JohnsonMowat
Planning & Development Consultants

29 November 2021

**RESERVED MATTERS PLANNING APPLICATION REF. 2021/1007
SUBMISSION OF REVISED AND ADDITIONAL MATERIAL**

drawing title
Planting Proposals Sheet 2 Phase 2A.1

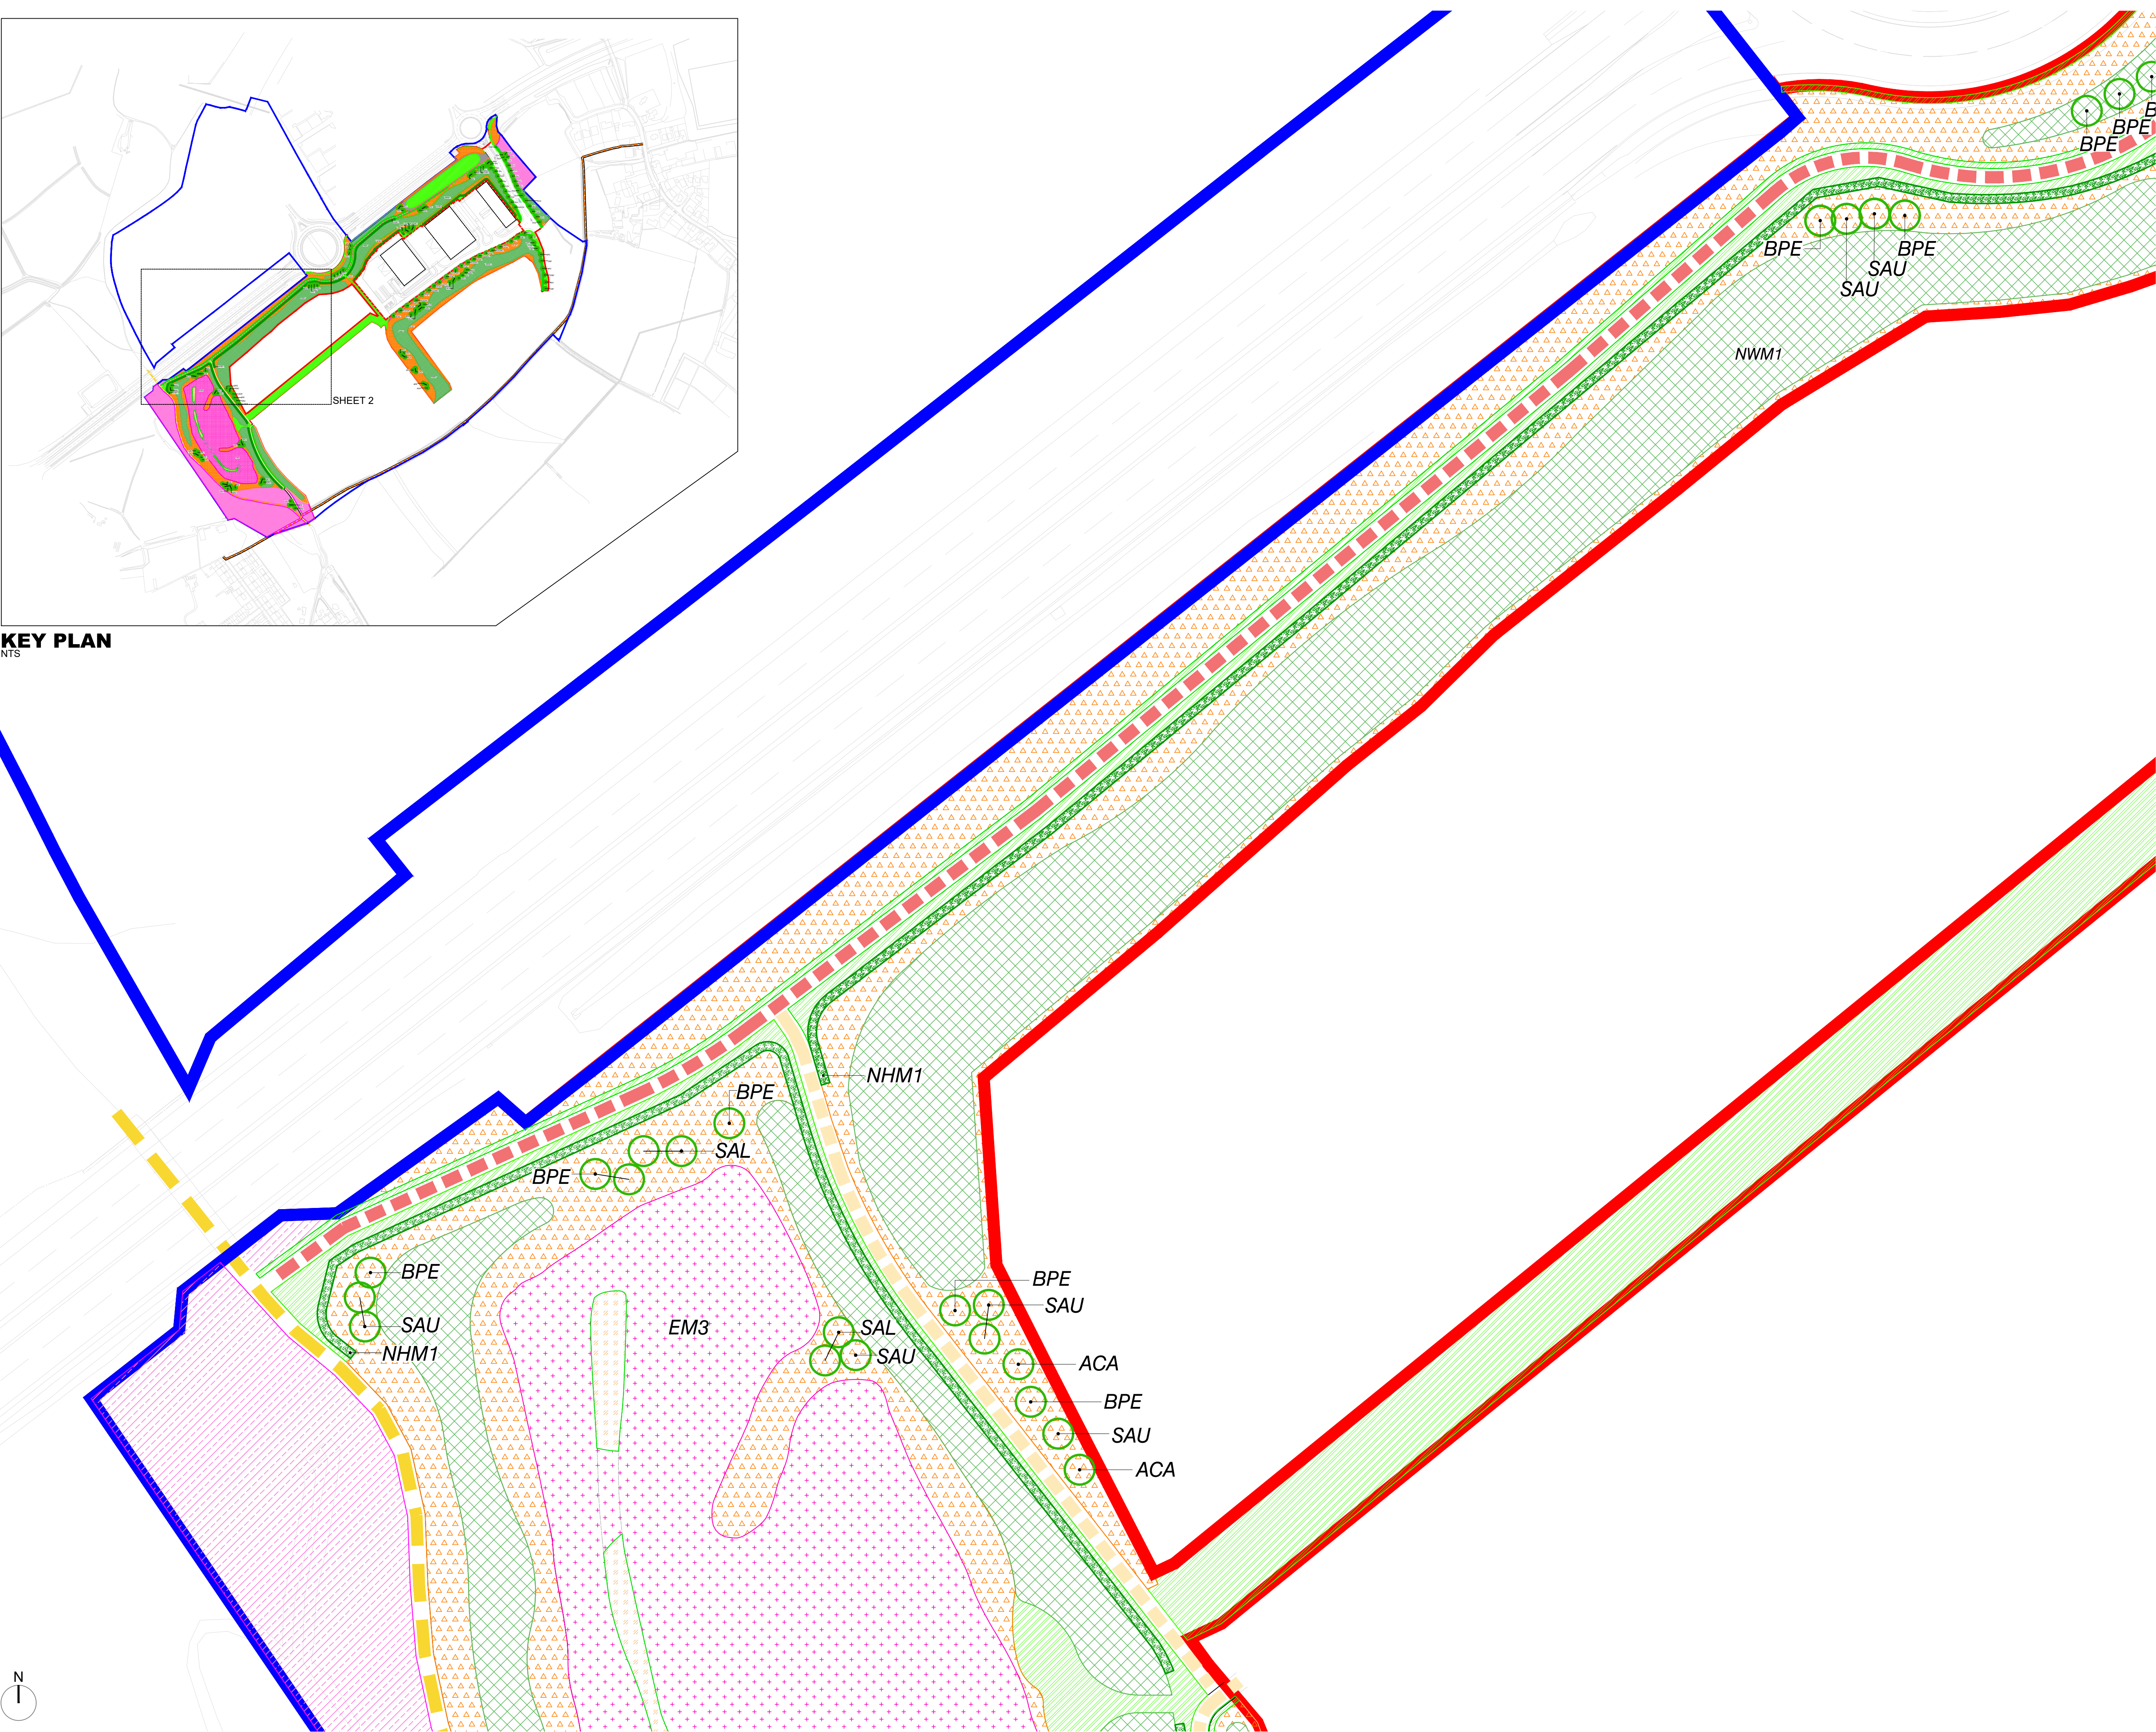
Unit 3 and its plot have been adjusted to locate the building slightly further southwest than its original position, with the plot being extended slightly to the west to maintain yard area whilst the car park is

now to wrap around the southwest corner of the building. The effect of this change is to set the building further into the main development area and reduce its prominence to the Dearne Valley Parkway and areas to the north. There is no change to the floorspace area of the unit.

Consequential changes have been made to the landscape planting within and around Unit 3 as a result of the changes made to this unit (see above). This includes the introduction of additional trees and native mixed species low level planting to the north boundary of the plot, with species rich eco flowering grass towards the building. The extent of low maintenance grass planting to the west of the plot is reduced.

Please note that changes to the paths are made to the landscape masterplan and planting plans where applicable. These changes relate to the paths only and not to the planting detail or other landscape features.

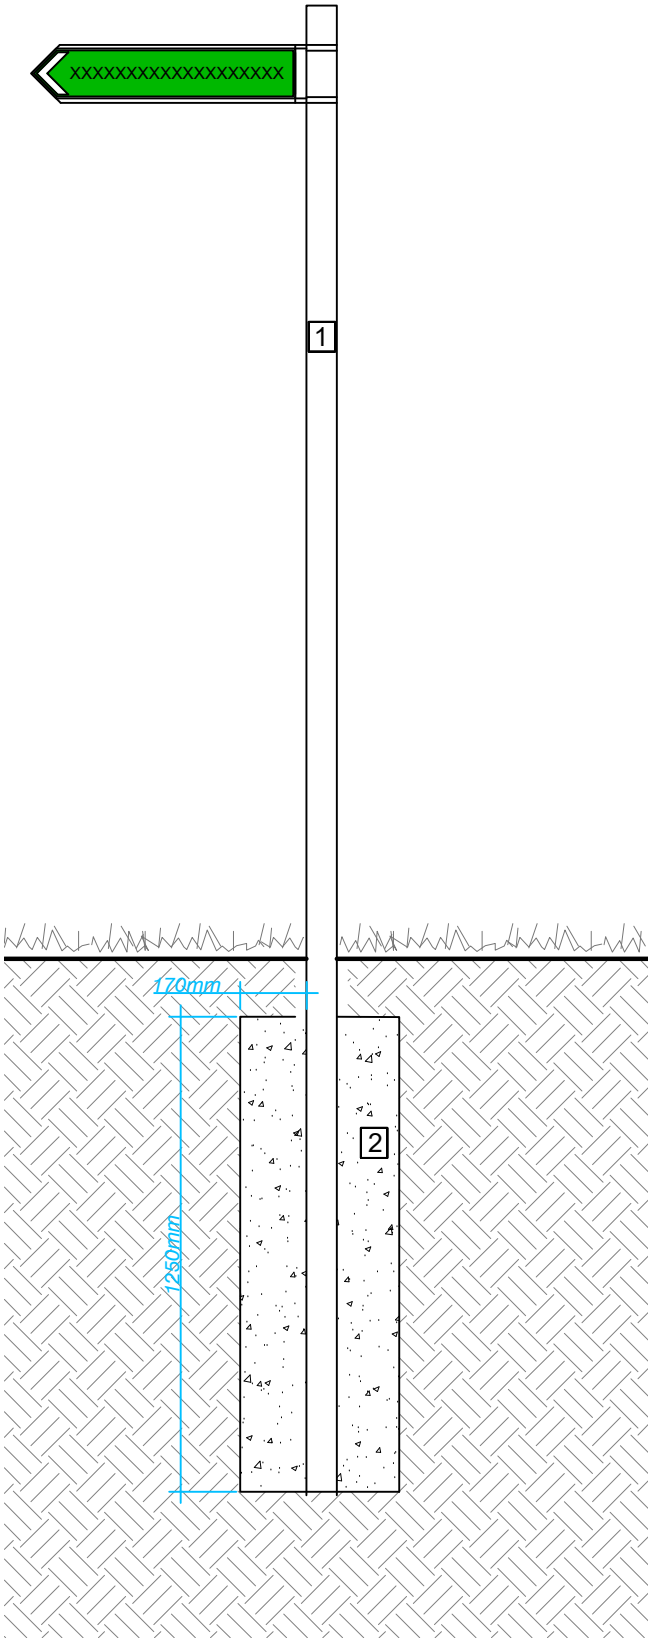
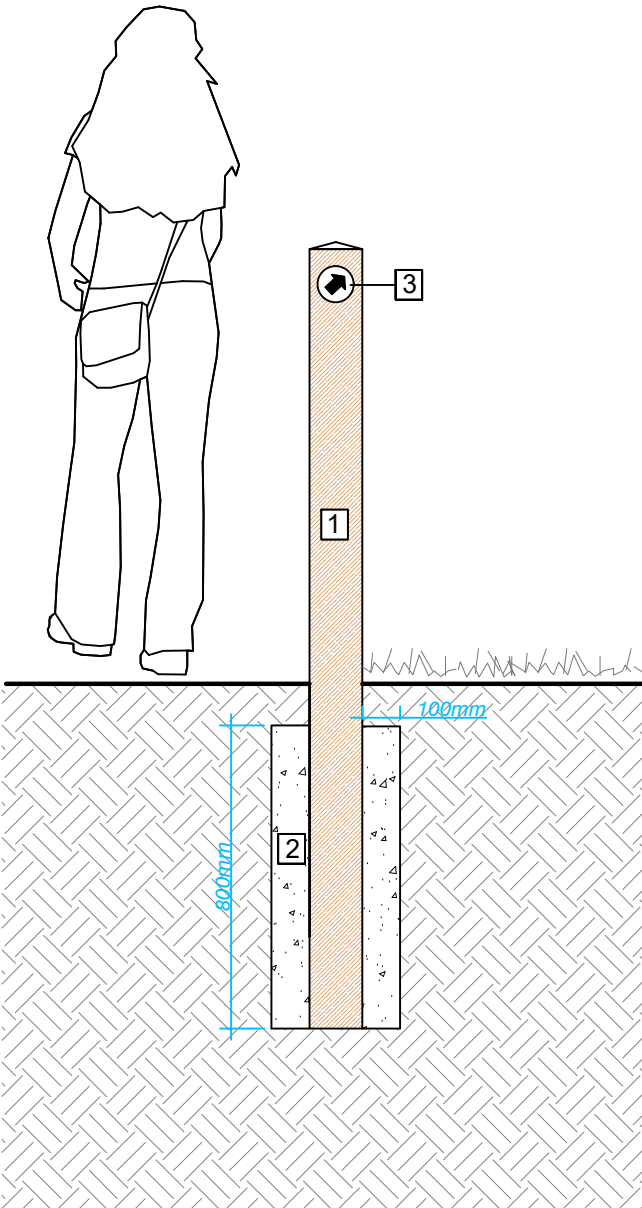
The paths and signage drawings have been reviewed and revised in response to the points made about path status/specification and signage.
